**Our Ref: Y/36/12/
Your Ref:**

Application for Planning Permission for Works or Extension to a Dwelling

Development Hard standing to front of property, dropped kerb & access ramp

Location 65 Foundry Road Yapton Arundel

No.	Description	Date
Amendments:		
Address:	65 Foundry Road Yapton BN18 0HE	Client: Mr A Page
Drawing Title:	Existing & proposed front elevations	Drawing Ref.: SG/02/Found65
Contact Details:		
Contact Address:		
Scale:	Paper:	Date:
1:50	A:2	5/7/2012
Revision No:		Checked By:
		Direction:

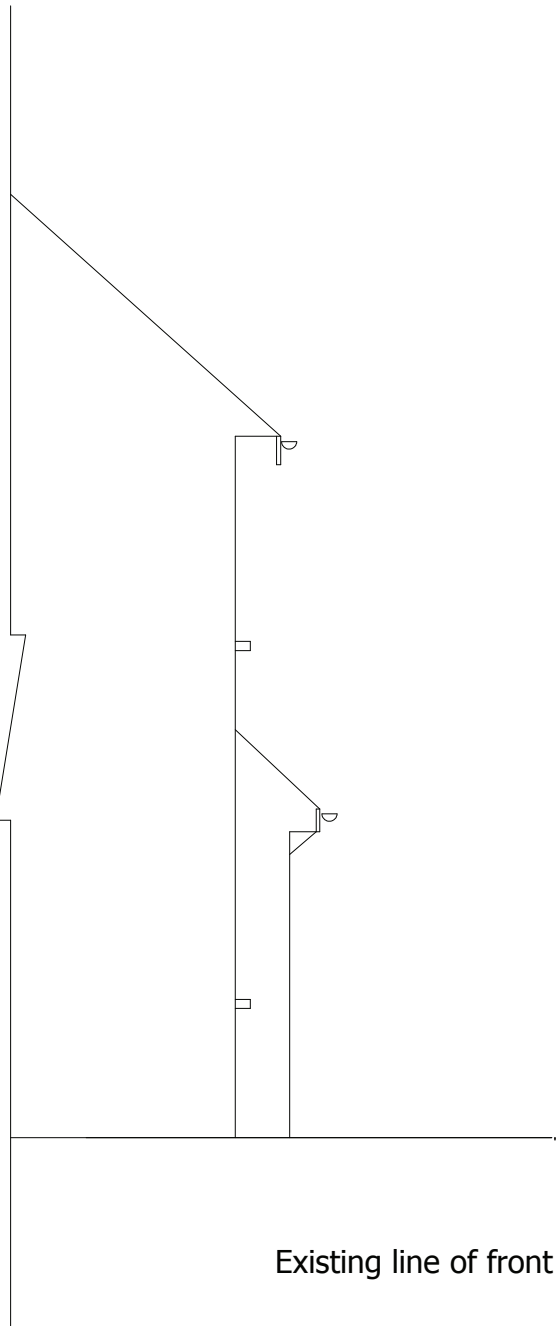
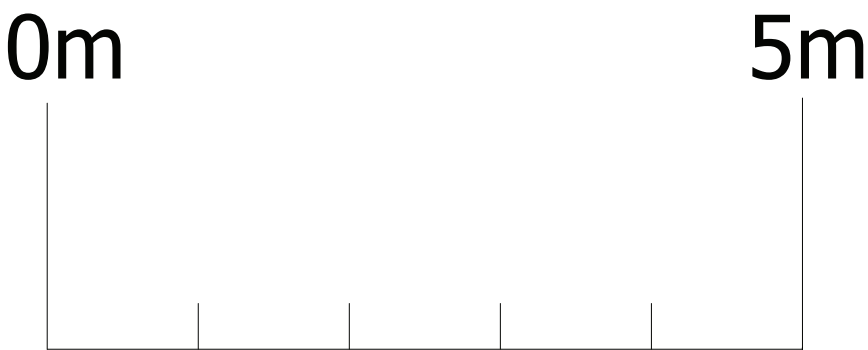
Please provide 1 electronic or 3 paper copies of proposed elevations of the ramp and existing/proposed elevations of the front boundary treatment (as applicable).

Site Plan
1:1250

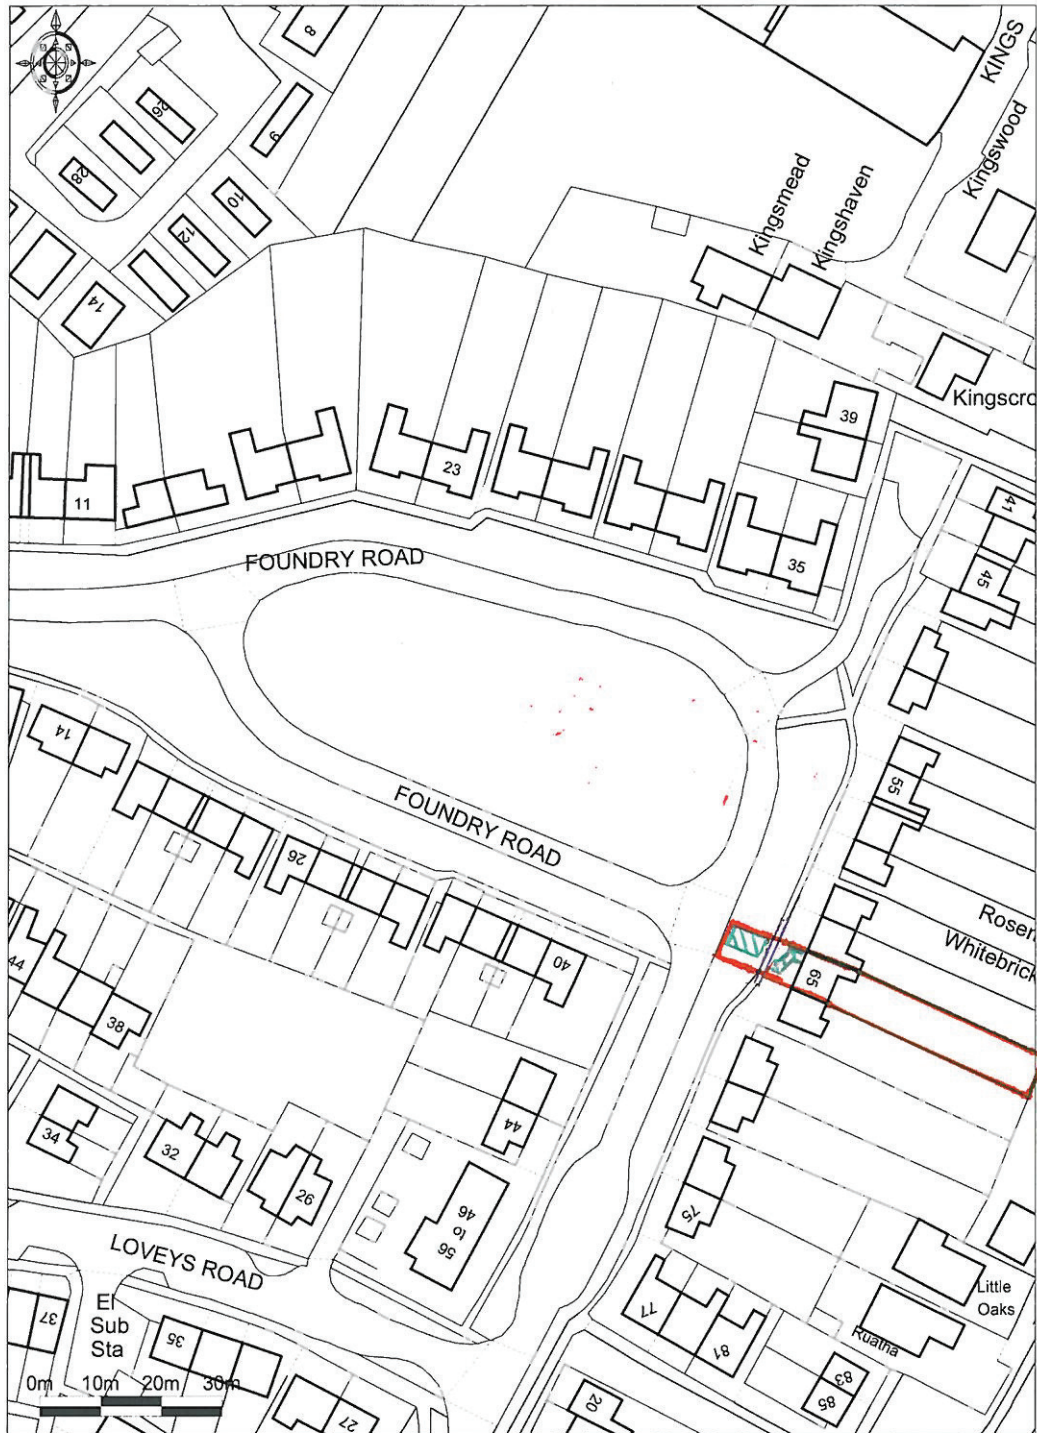
I require 1 electronic or 3 paper copies of a revised block/site plan to include the dropped kerb and a north point. Please also mark the proposed works in a different colour, as a red edge should only be used to indicate the site area and must match the location plan.

I require 1 electronic or 3 paper copies of a revised location plan showing a red edge to include position of dropped kerb.

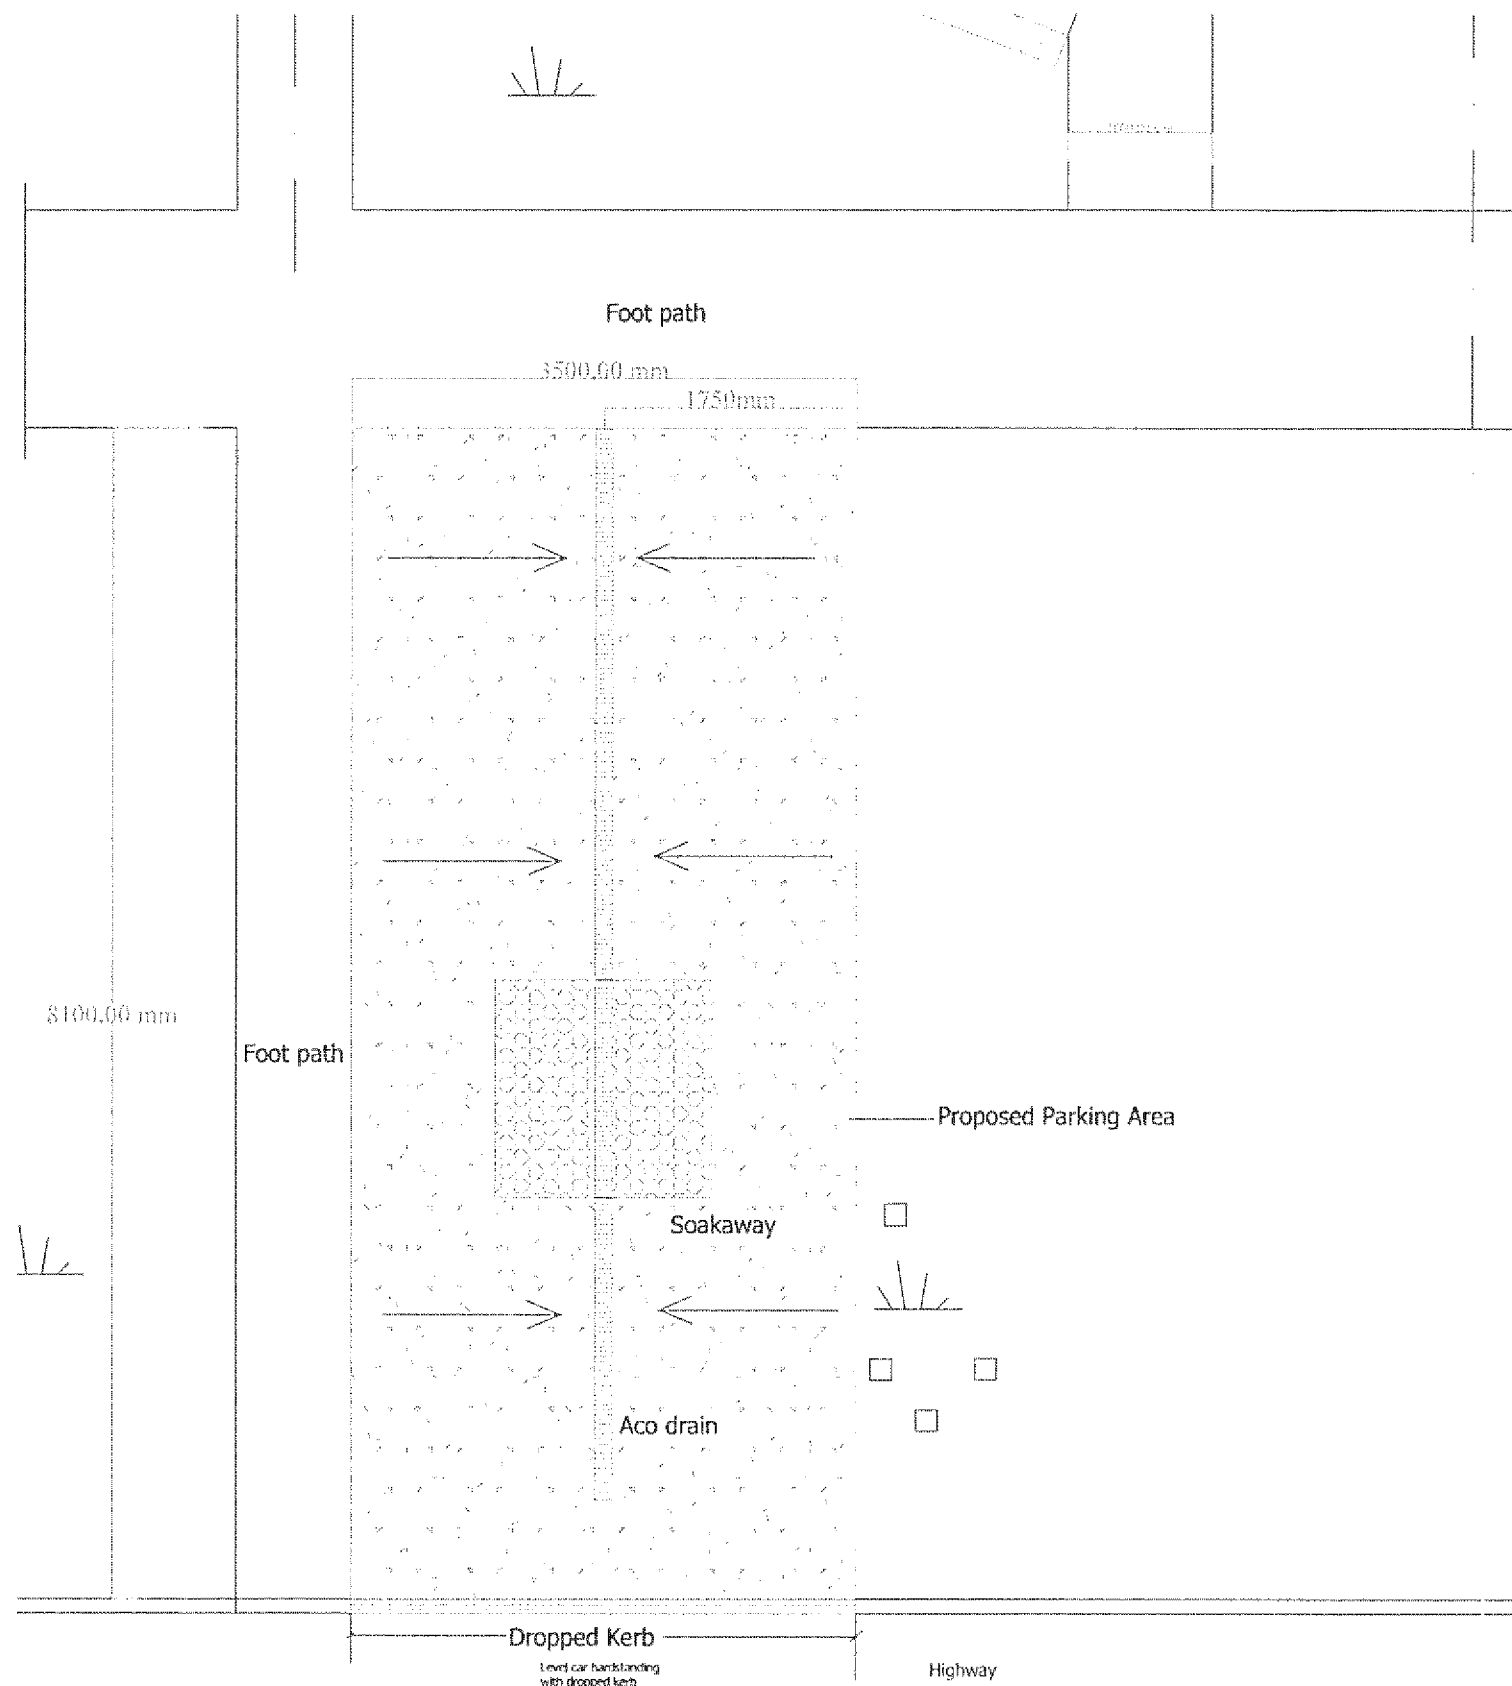
Please provide 1 electronic or 3 paper copies of an existing and proposed plan at 1:100 or 1:50.
